04/02/2021

**Kariong Sand and Soil Supplies Facility (SSD-8660)
Request for Additional Information**

Attachment 1 Department's Comments on the Supplementary RtS

DRAWING TITLE **HYDRAULIC SERVICES STAGE 1 SANITARY & TRADE WASTE LAYOUT**

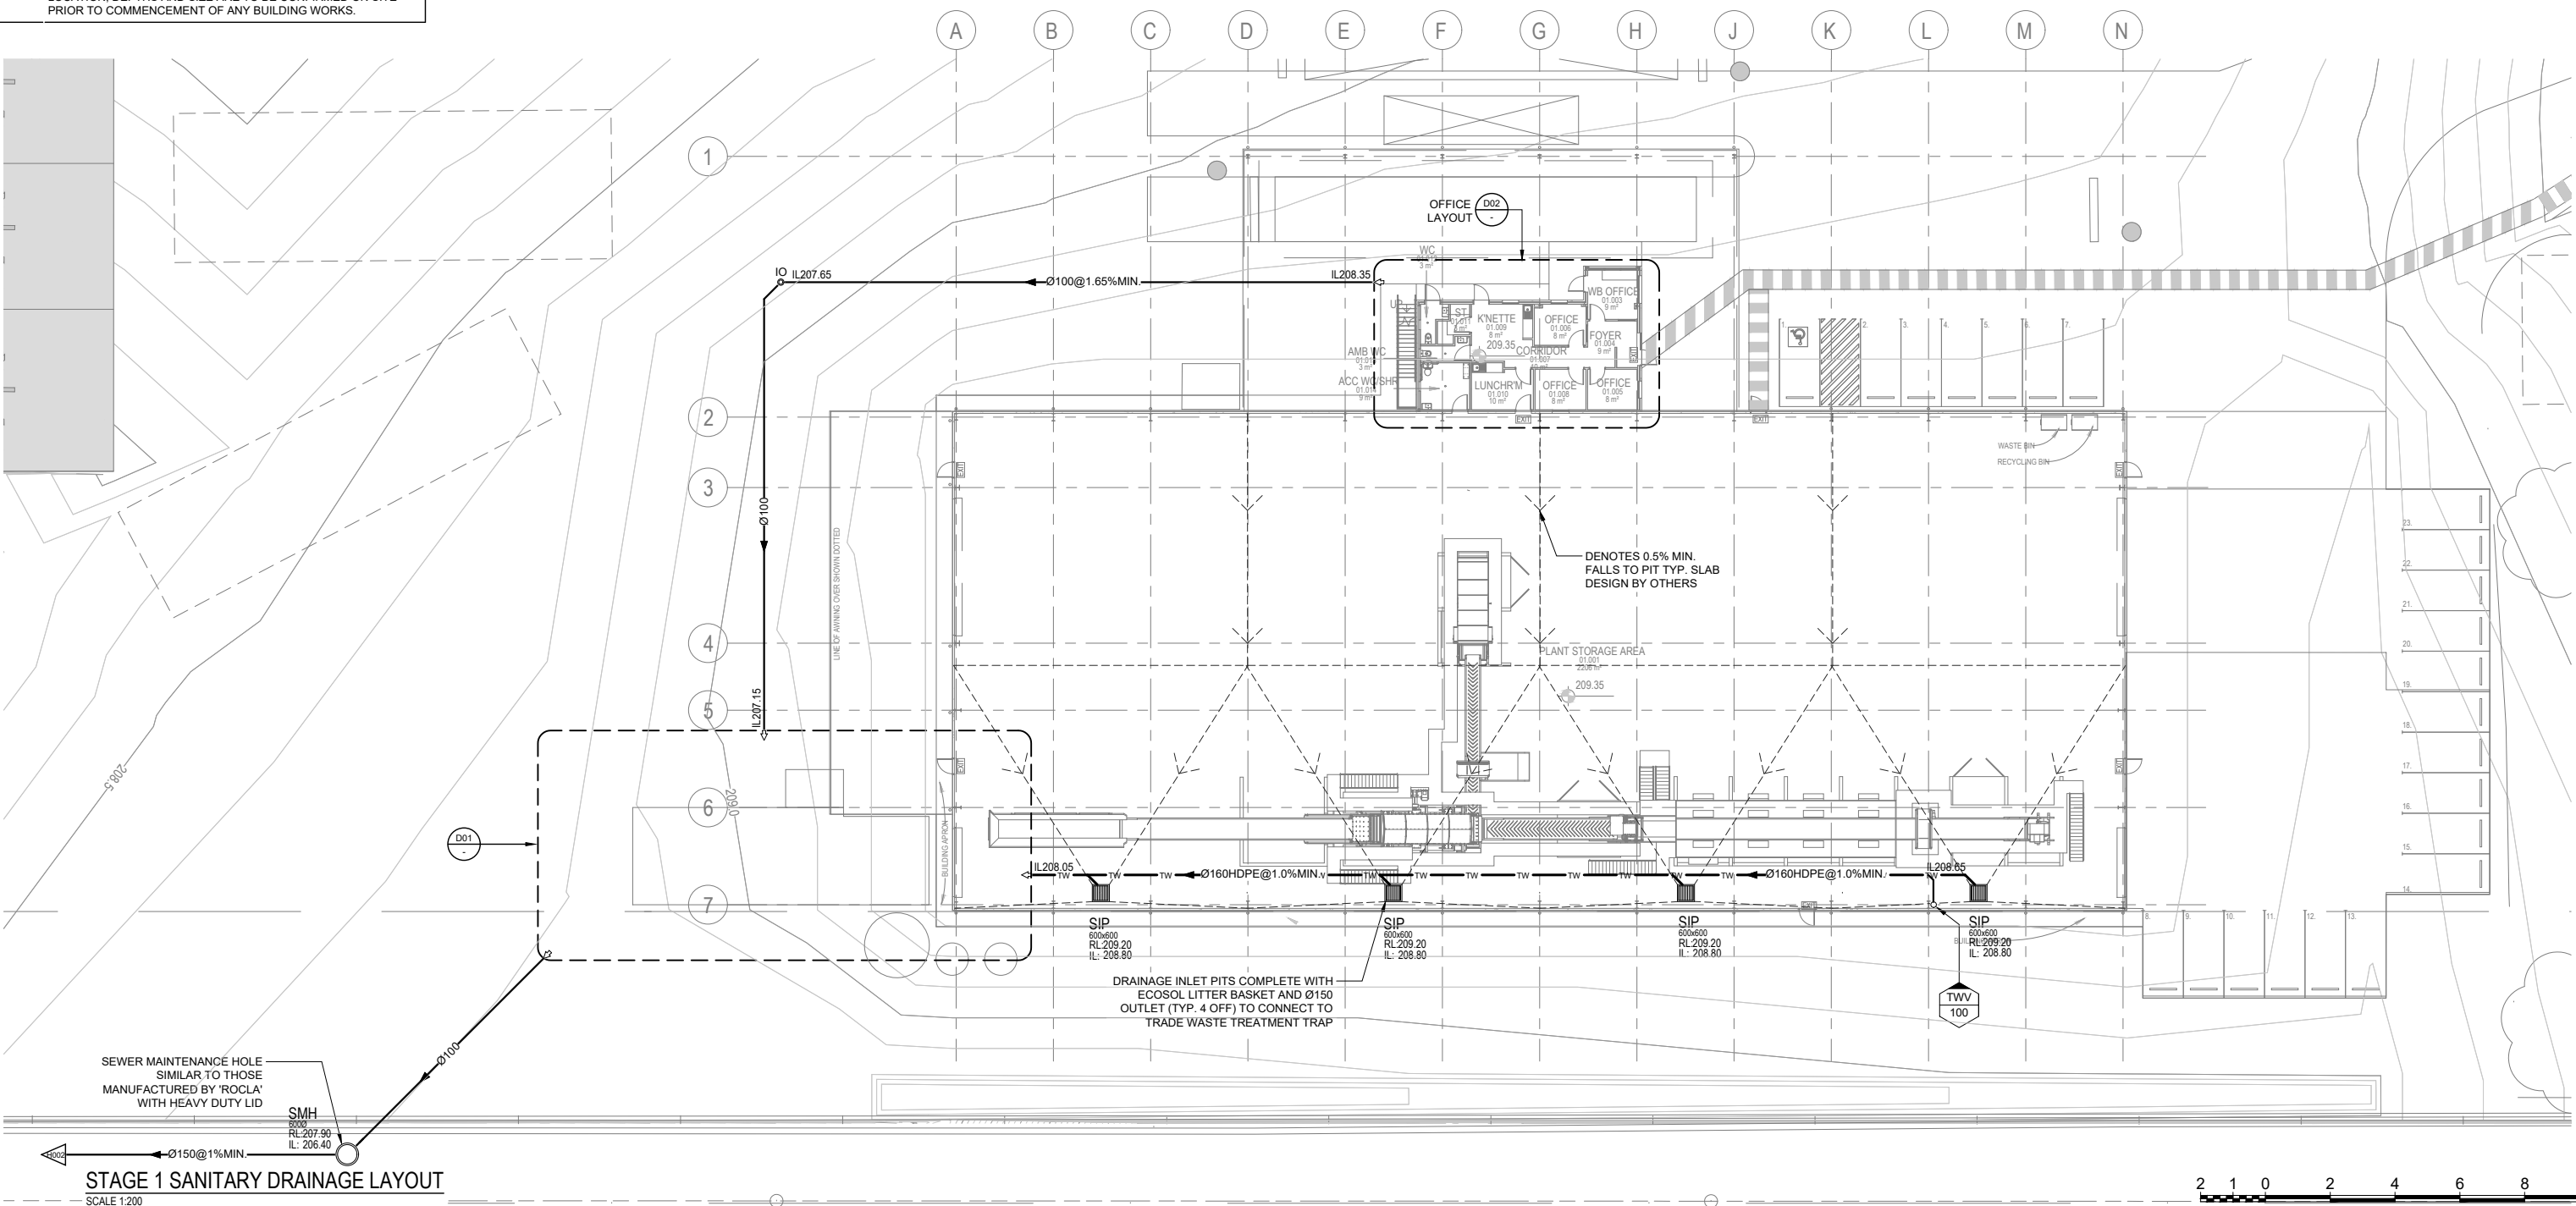
3. The Department notes the development proposes to construct sewers along the eastern boundary of the southern half of the site to connect to Council's sewage main on Kangoo Road. Please clarify whether construction of the sewers requires clearing of the existing bushland which is proposed to be retained and whether this has been addressed in the Biodiversity Assessment Report. Please clarify the total area to be removed, any biodiversity impacts caused by the vegetation removal, and resulting biodiversity impact offset requirements.
